**CITY OF PORTLAND, ME
BOCA 1996 Plan Review Record
One and Two Family Dwelling**

Building Location: 32 Buca Run (Lot #8) CBL: 336-H-058

Building Description: Single Family dwelling.

FOUNDATION 32'-0"

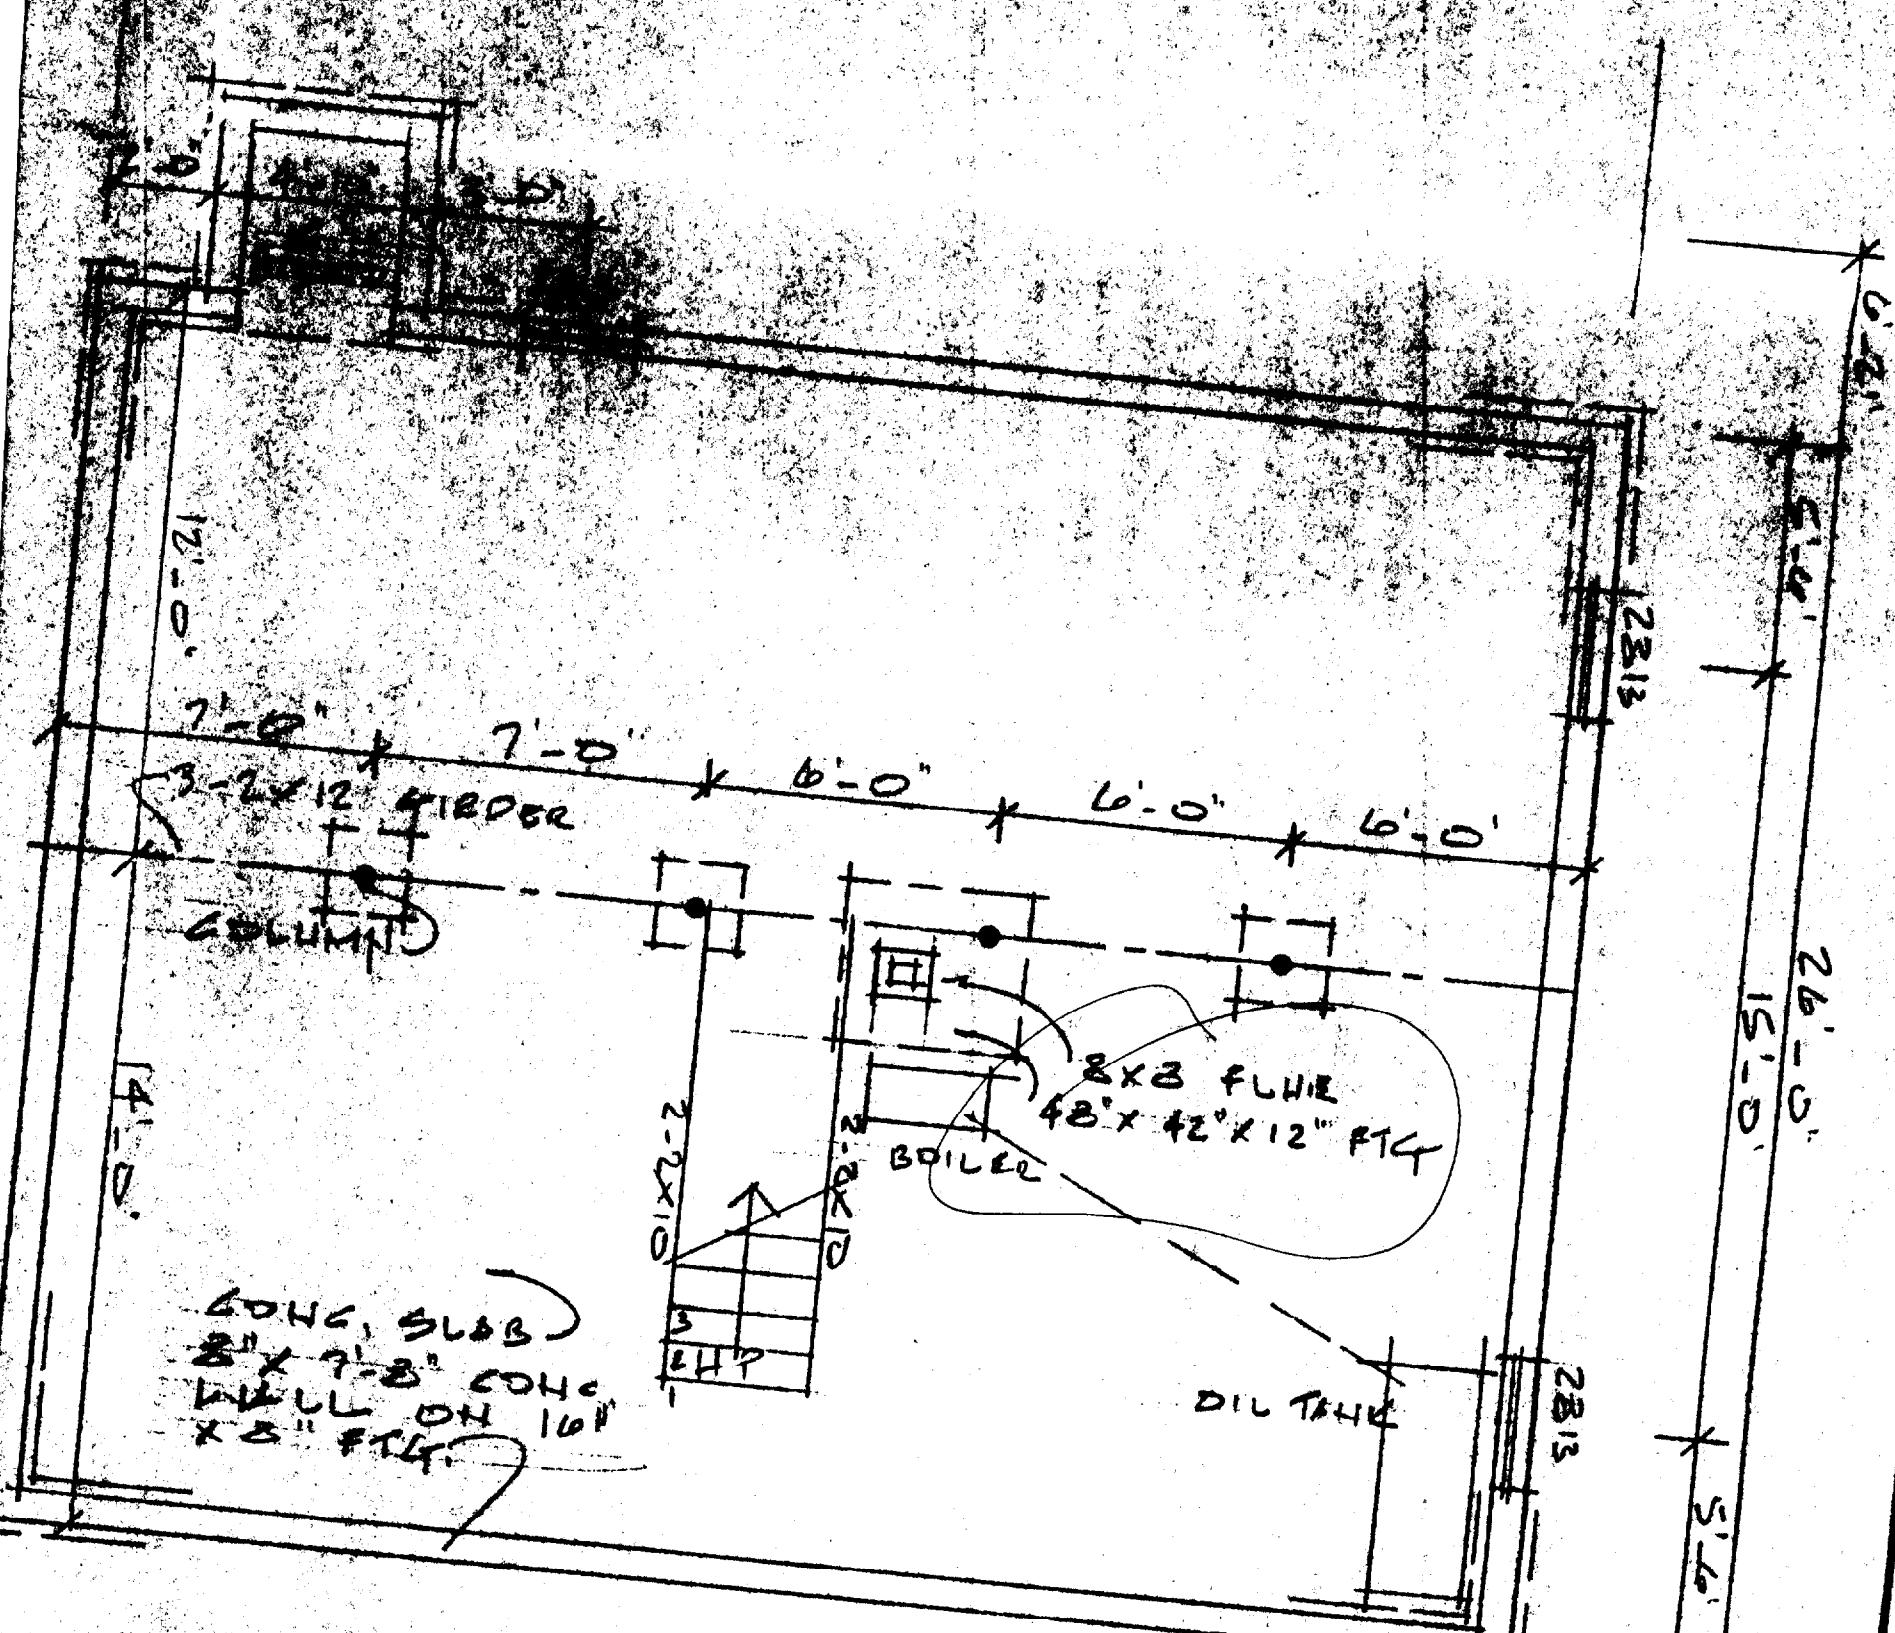
~~OK~~ Design (1812.1)
~~OK~~ Minimum thickness Tables 1812.3.2(1) & 1812.3.2(2)
~~SM~~ Water proofing and damp proofing Section 1813
~~OK~~ Sill plate (2305.17)
~~SM~~ Anchorage bolting in concrete (2305.17)
~~OK~~ Columns (1912)
~~AT~~ Crawl space (1210.2) Ventilation
~~NA~~ Crawl opening size (1210.2.1)
